About the application

Application number: 2025/93572	
What is the application for?:	Outline application with all matters reserved, bar vehicle access into the site,
Address of the site or building:	Land South of, Barnsley Road, Upper Cumberworth, Huddersfield, HD8 8NN
Postcode:

Type of comment: An objection	
Do you wish your comments to be published on the website anonymously?	<input checked="" type="checkbox"/> Yes
DESIGN OBJECTION	
<p>The proposed layout for application 2025/93572 represents a fundamentally poor and inappropriate form of urban design that fails to respond sensitively to the site's Green Belt location, adjacent ancient woodland, existing landscape structure, and natural topography. Rather than a landscape-led scheme informed by environmental constraints, the proposal appears to impose a dense suburban housing estate onto a highly sensitive rural site with little genuine regard for its context.</p>	
<p>One of the most serious failings of the proposal is its treatment of the adjacent ancient woodland, Stephens Wood. Ancient woodland is an irreplaceable habitat and should be afforded the highest level of protection. National planning guidance and Natural England st

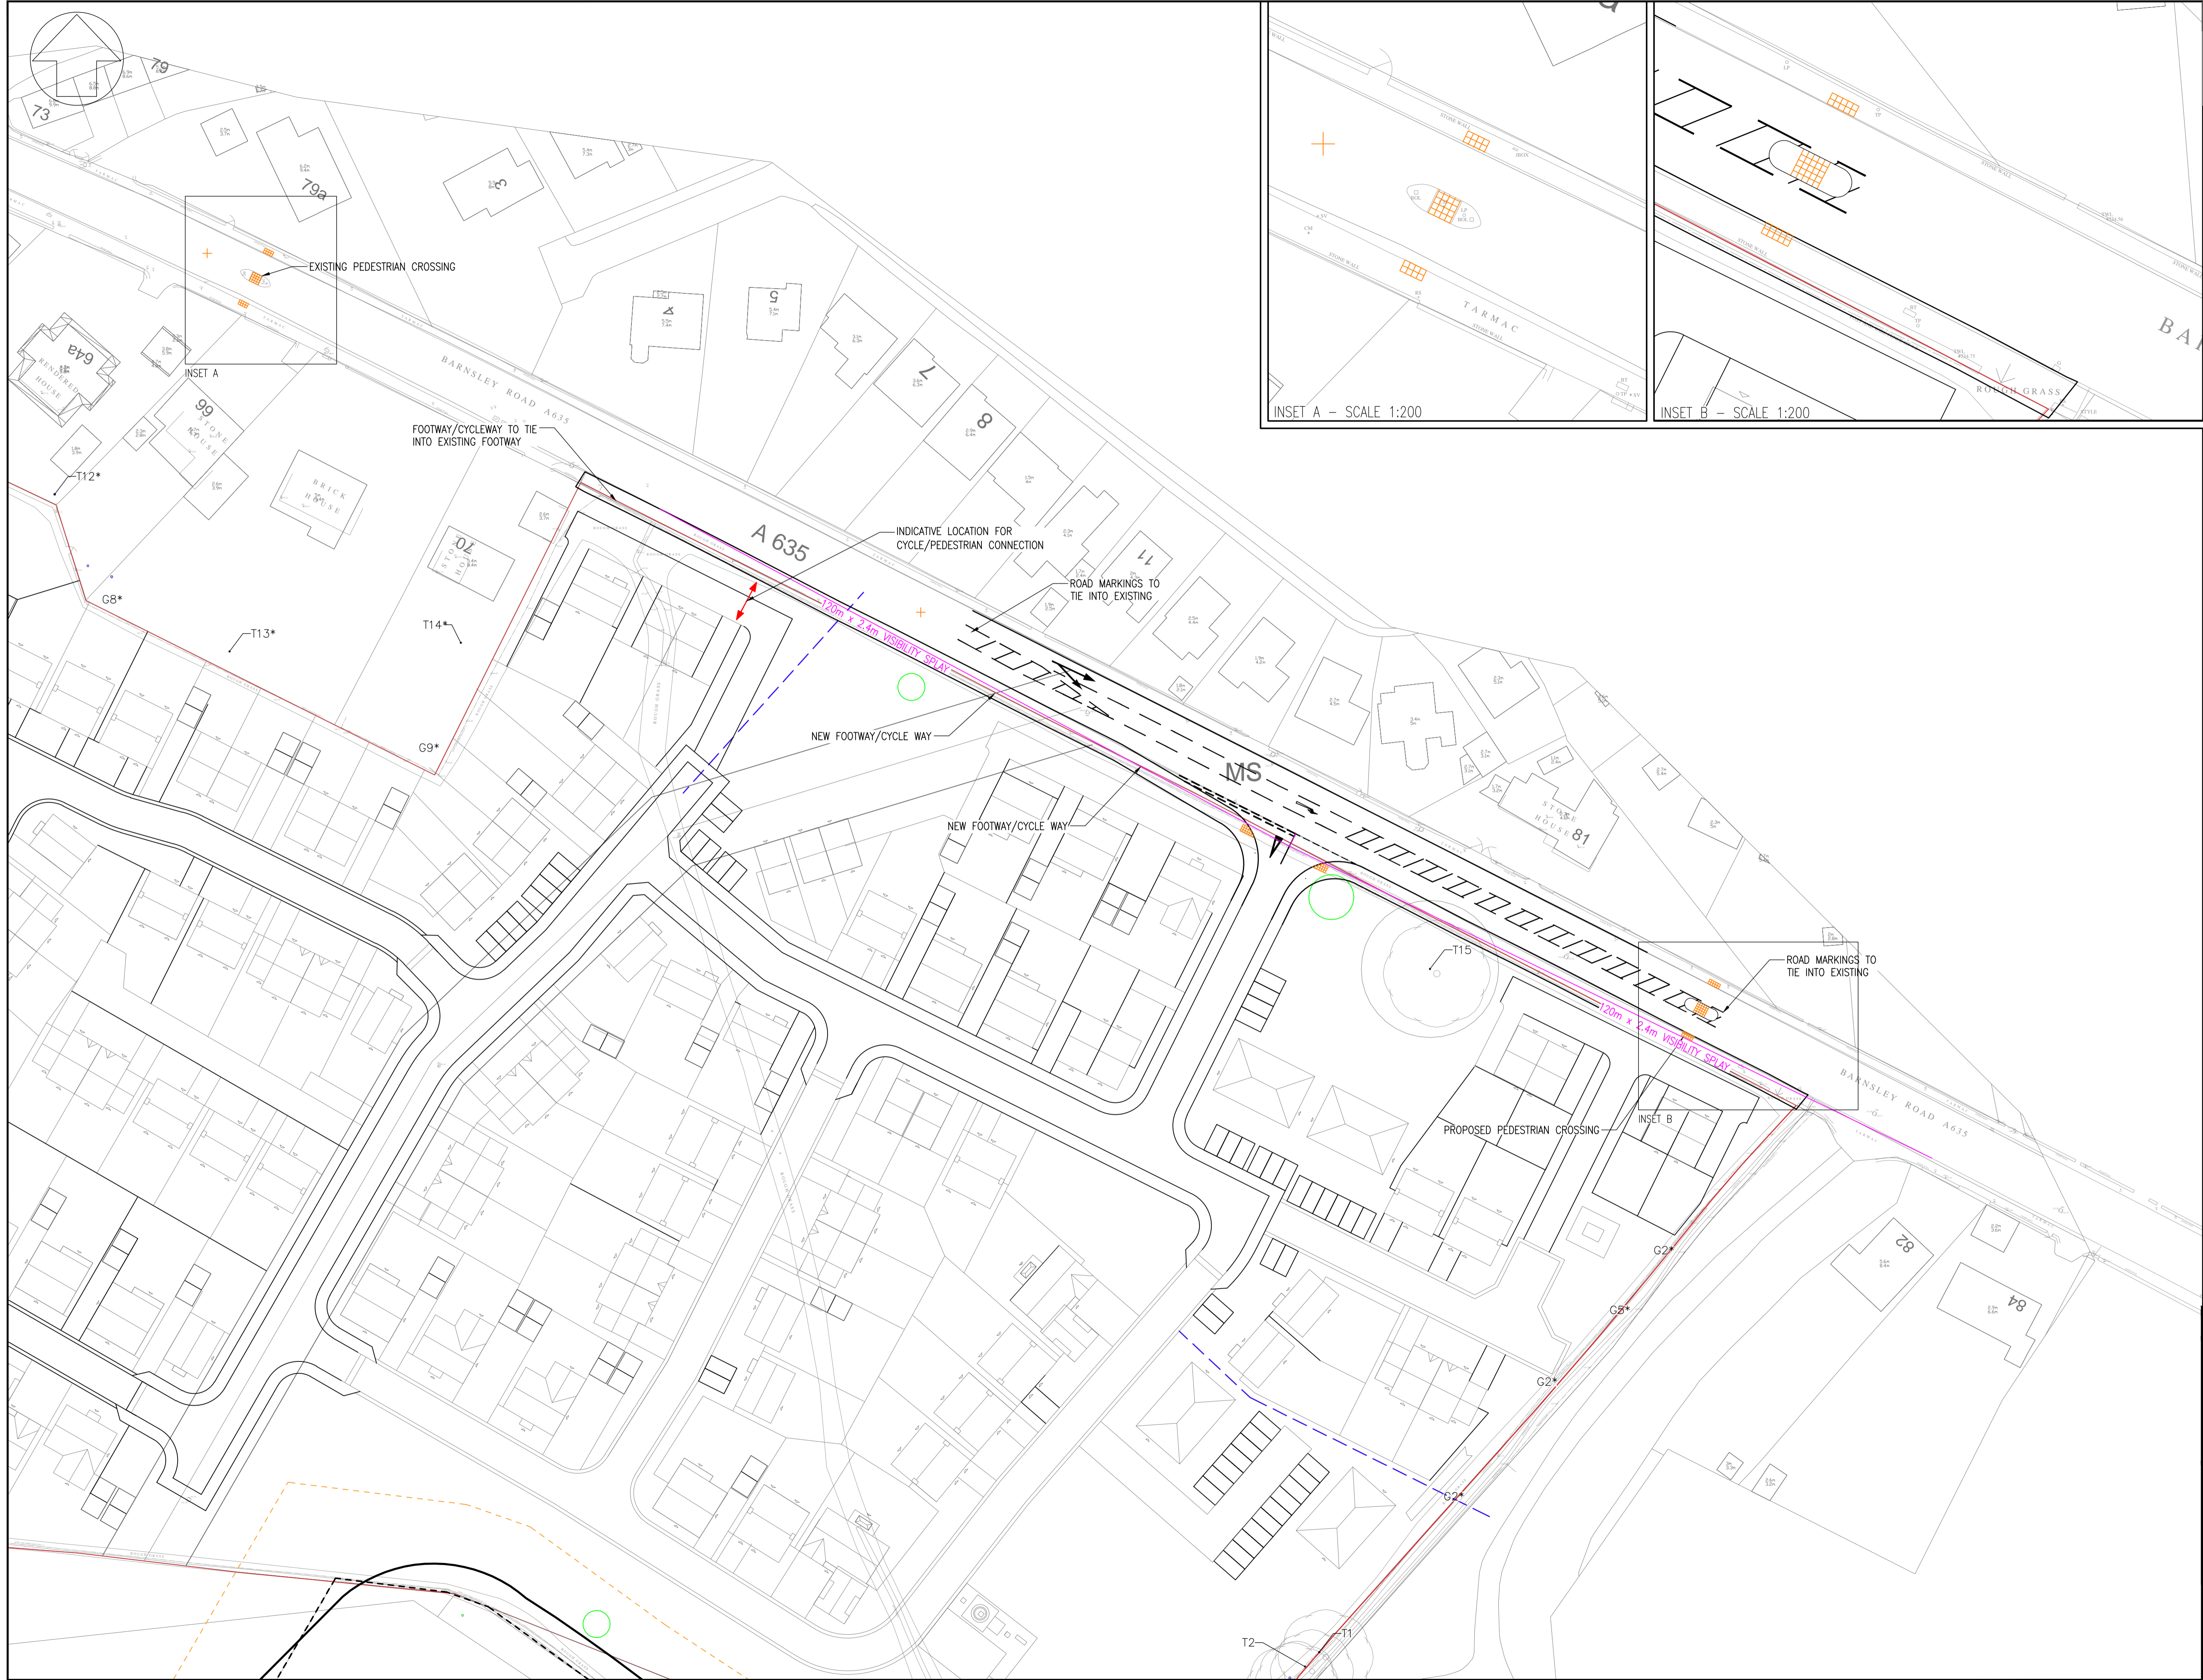
<p>A minimum 50 metre buffer should be provided between built development and ancient woodland in order to reduce impacts from noise, lighting, domestic activity, drainage changes, invasive species, and recreational pressure. Instead, the submitted layout pushes roads, rear garden boundaries, and housing parcels directly toward the woodland edge, creating an abrupt and harmful urban interface. The tokenised "semi-natural buffer" shown on the plan is fragmented, inconsistent in width, and clearly designed as leftover space rather than meaningful ecological protection.</p>	
<p>The proposed arrangement would expose Stephens Wood to long-term degradation through increased human activity, fly tipping, garden encroachment, pet predation, and artificial lighting. Rear gardens facing ancient woodland are particularly poor urban design practice because they create unmanaged edges and encourage future pressure for tree removal, fencing alterations, and informal access points into sensitive habitats. The development effectively turns ancient woodland into the back fence of a suburban estate, which is entirely inappropriate.</p>

The layout also demonstrates very limited respect for the existing mature trees and landscape structure across the site. The development pattern appears engineered primarily to maximise housing numbers rather than retain and integrate landscape features. Large areas of hardstanding, road infrastructure, and tightly packed housing blocks dominate the site plan, leaving tree planting and green space as secondary afterthoughts. The proposed tree planting cannot compensate for the loss of openness or for the pressure placed upon established vegetation and woodland edges.

Equally concerning is the apparent disregard for the site's natural topography. The land slopes significantly toward the woodland edge, yet the proposed estate adopts a standardised suburban road hierarchy with little evidence that the design has evolved in response to landform.

This creates an overly engineered appearance that would likely require substantial cut-and-fill operations, retaining structures, and ground regrading in order to deliver developable housing platforms. Such interventions would permanently urbanise the landscape and erode the site's rural character.

Good urban design should work with natural contours and reinforce local landscape character. Instead, the proposed layout introduces rigid estate geometry and repetitive housing parcels that could be placed almost anywhere. There is little sense of place or relationship to Upper Cumberworth's historic settlement pattern.

The scheme lacks any meaningful transition between countryside and development, resulting in a harsh suburban edge that would appear visually intrusive when viewed from surrounding public areas and nearby countryside.

The density and arrangement of housing also create concerns regarding overdevelopment. The concentration of built form across the site leaves insufficient space for meaningful green infrastructure, ecological corridors, or visual relief. Open spaces appear fragmented and residual rather than functional landscape assets. This reinforces the impression that environmental considerations have been subordinated to maximising yield.
